**Application by Thurrock Power Ltd for an Order granting Development Consent for Thurrock Flexible Generation Plant Project**

**Written Representation submitted on behalf of Network Rail Infrastructure Limited**

**Planning Inspectorate Reference No: EN010092**

**Thurrock Flexible Generation Plant
 Illustrative General Arrangement Plans
 Sheet 3 of 5**

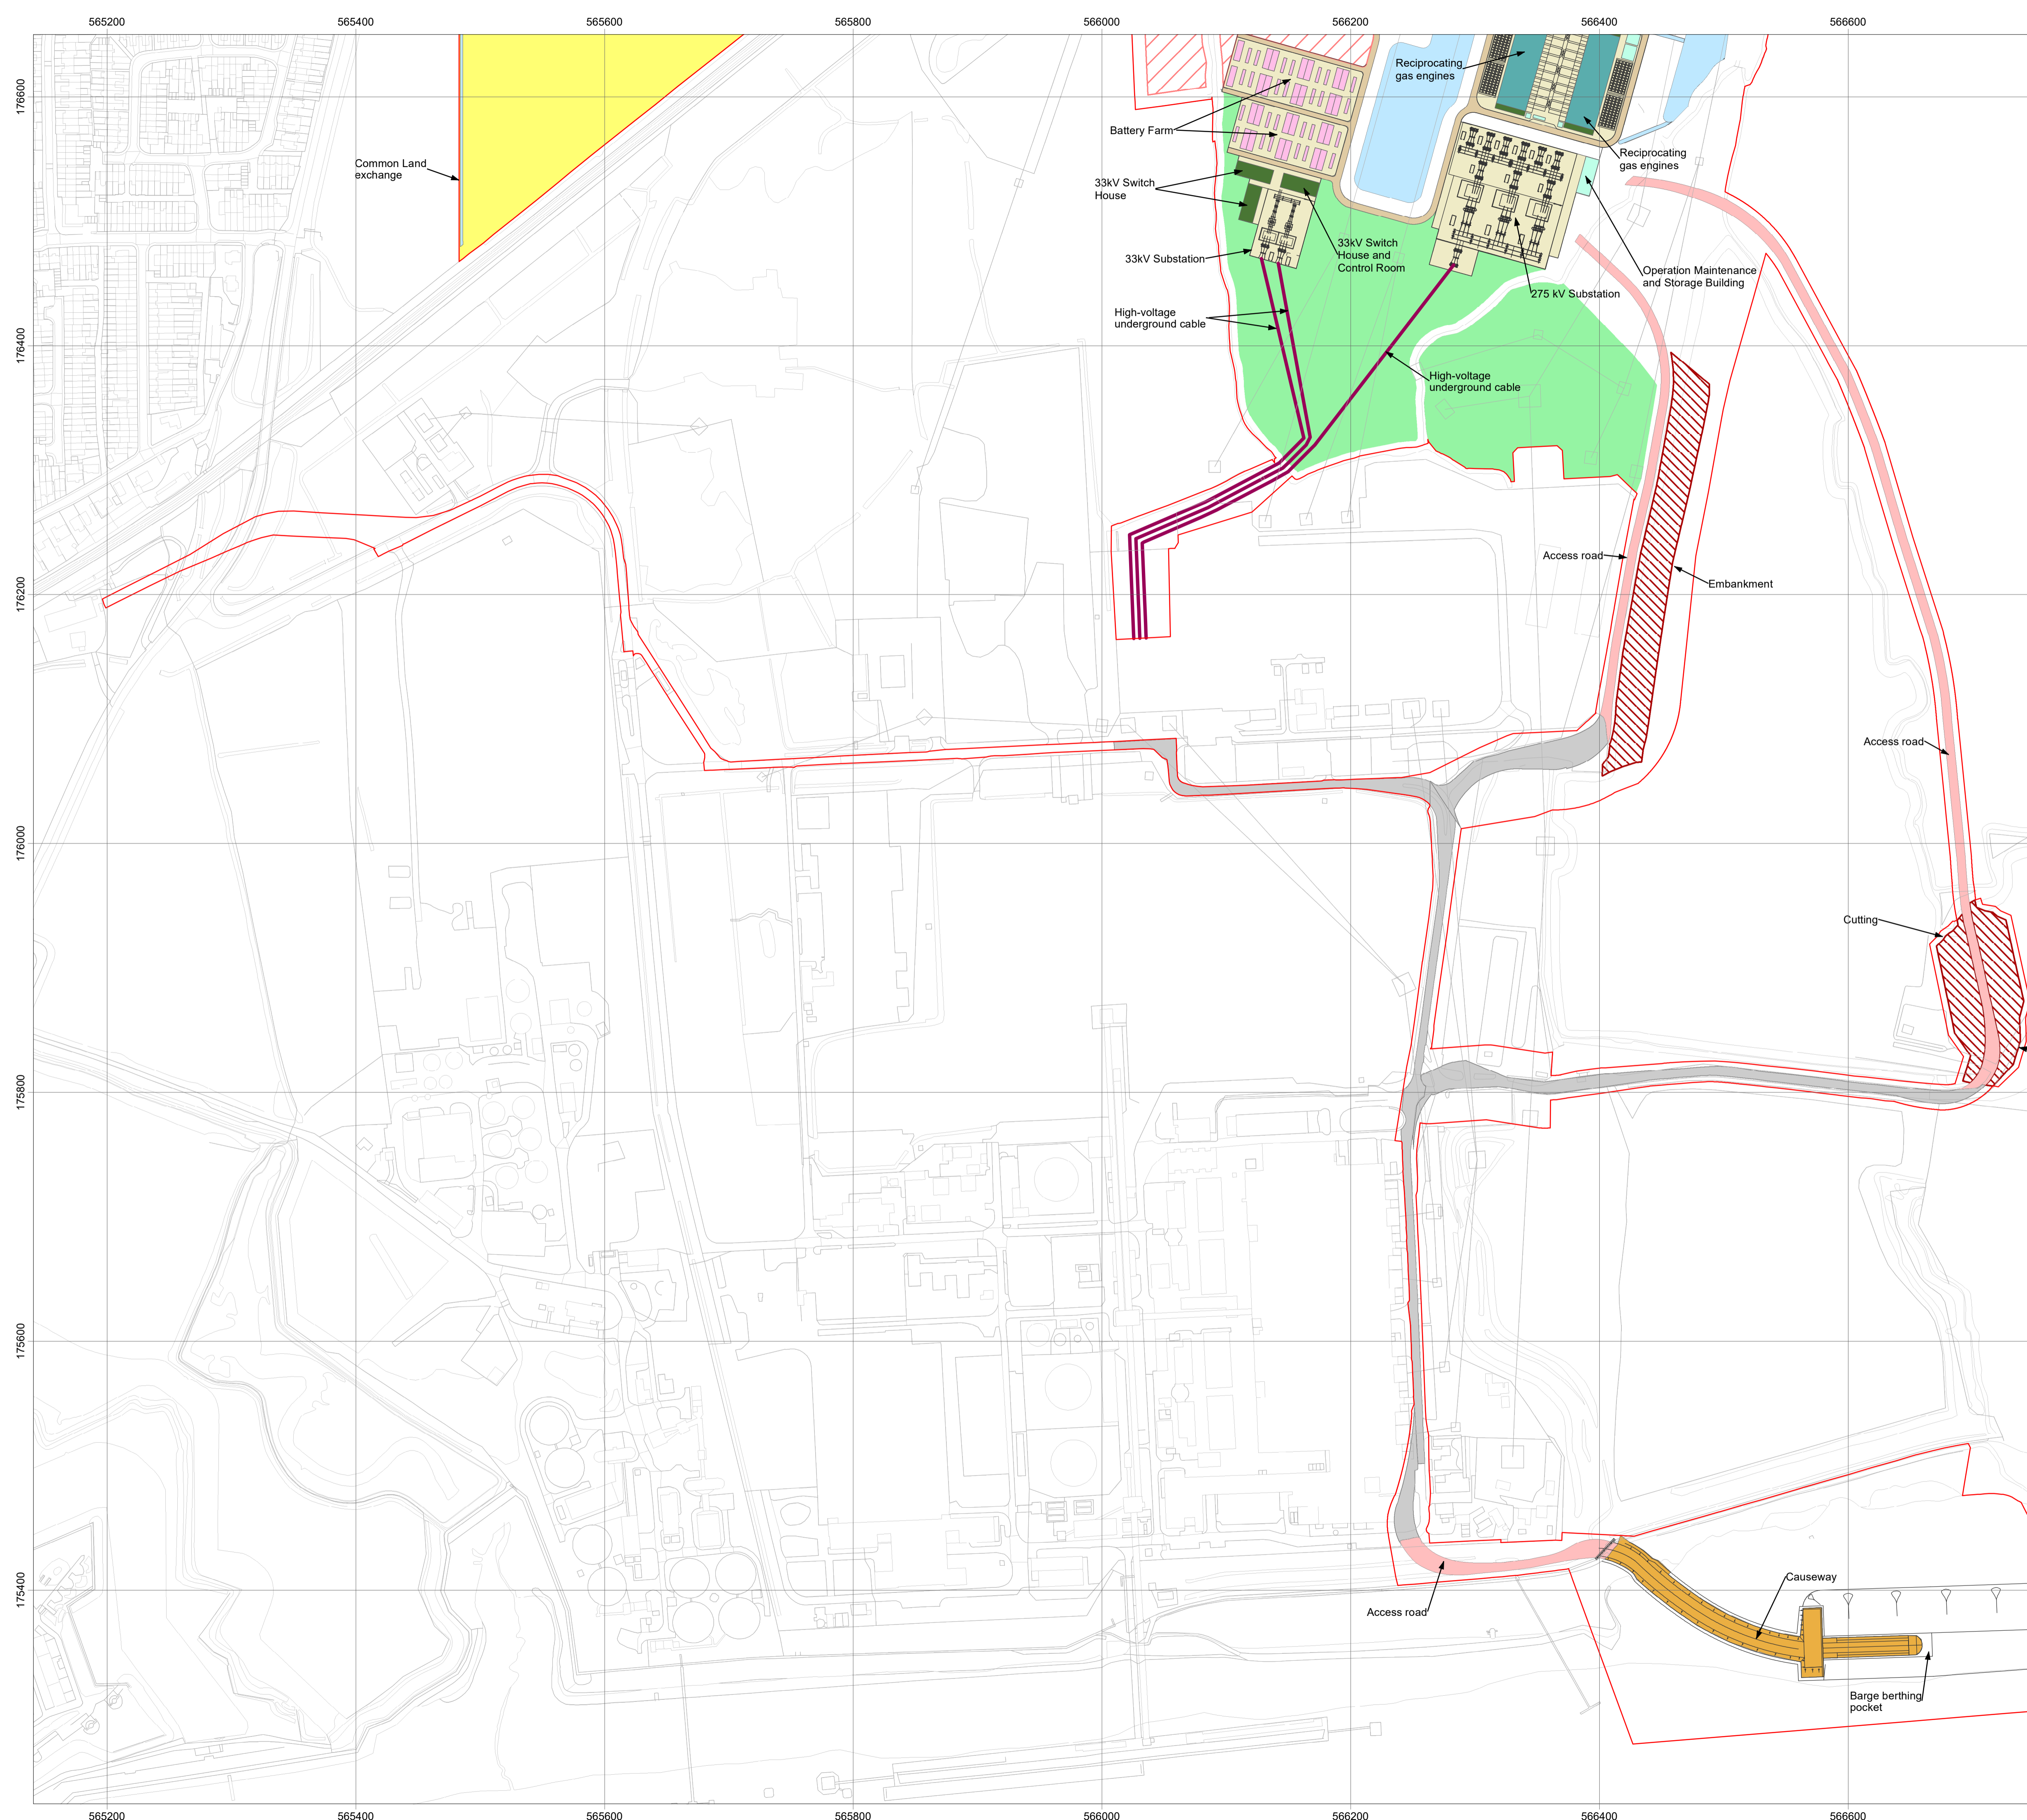
- 3.1 The Applicant proposes to construct an access road (**Access Road**) from Station Road to the site of the Proposed Development. It is proposed that the Access Road will join Station Road 45 metres south-east from the stop-line of the Low Street level crossing. Network Rail considers that the location of the proposed junction of the Access Road is unacceptable from a safety and performance perspective as it could lead to additional congestion on Station Road at the approach to Low Street level crossing. Network Rail therefore requests Work no. 6 is amended so that the location of the junction is increased to 90 metres from the stop-line of the Low Street level crossing.

- 3.2 Network Rail is also concerned that the proposed location of the Access Road is too close to the Railway Line and considers further mitigation measures should be put in place to prevent vehicle incursions onto the track. This is particularly concerning given that the Extraordinary Route provides for the use of the Access Road by AILs if required, which pose a significant risk to the Railway Line and its users if an incursion occurred blocking the track leading to damage of assets, delays to railway services and costly repairs to rectify. To mitigate against these risks, Network Rail requests the Applicant assesses these risks and ensure that mitigation measures such as the installation of road vehicle incursion measures are fully considered and adopted as part of Work no. 6 of the Proposed DCO or that the position of the Access Road is moved further to the south-east, away from the Railway Line.

- 3.4 Network Rail are also concerned that the presence of vehicles on the Access Road, particularly when using the junction, will have an adverse impact on rail traffic. In particular, that lights present on such vehicles and other plant and equipment could be confused for signals by train drivers. Network Rail therefore request amendments to Work No. 6 of the Proposed DCO to introduce solid fencing to a height to shield the Railway Line from lighting.
